5<sup>th</sup> September, 2017

re: **Blastreat and Greenhurst**  
**AB/77/17/PL**

Second Floor Plan

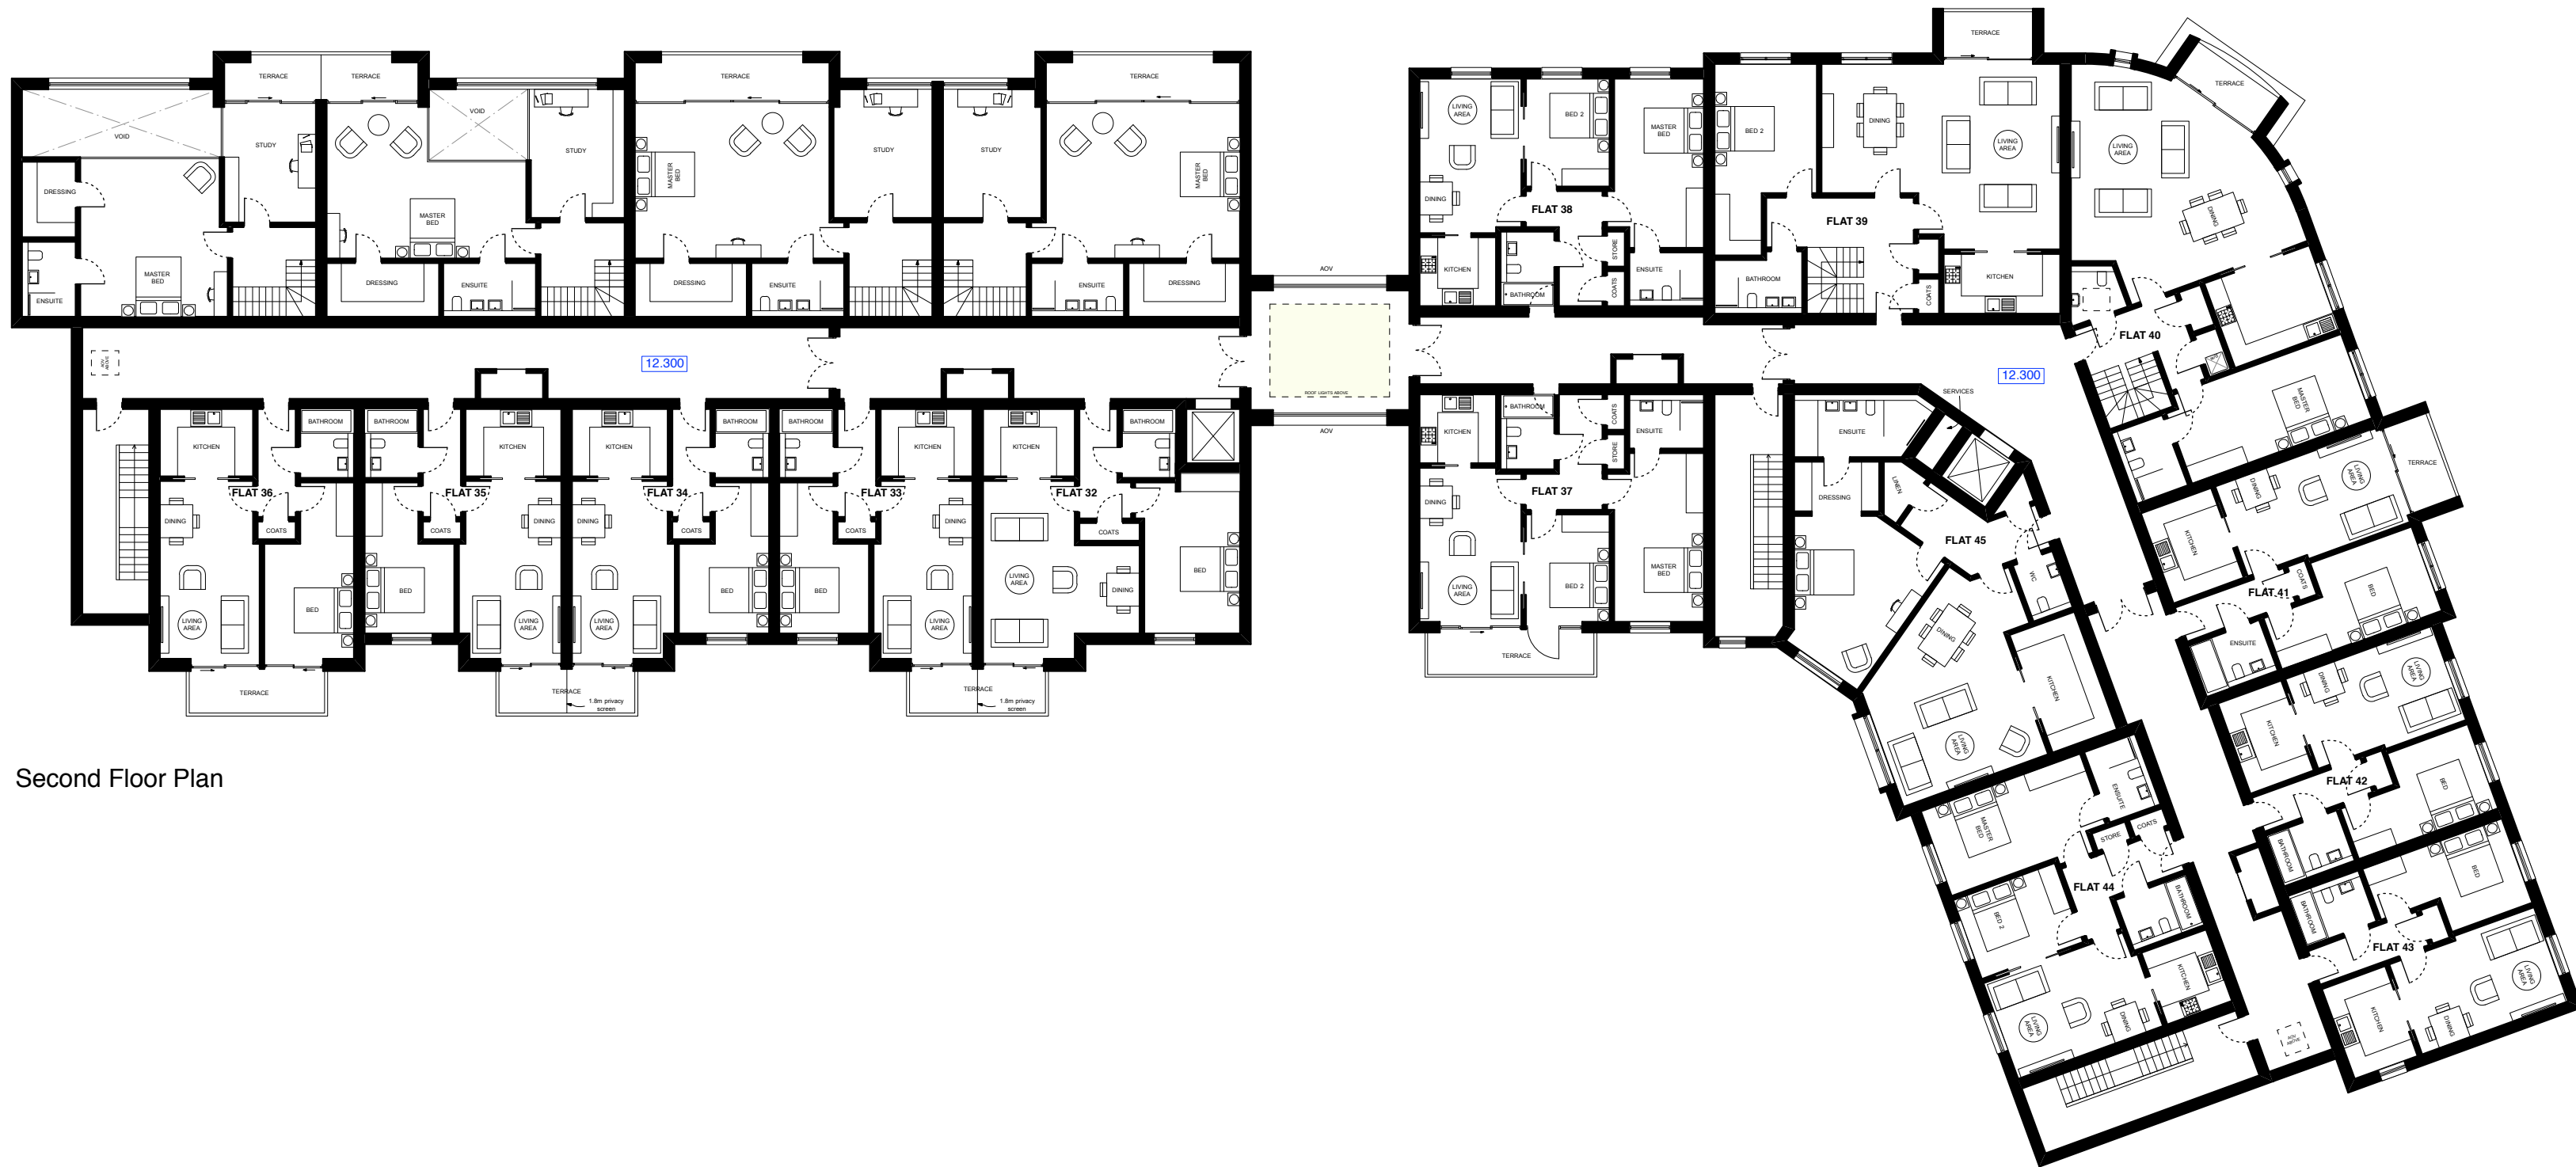
1. The height of the proposed development would face directly onto Otmers Quay and completely overpower the existing houses which are of standard build, i.e. ground and first floors.
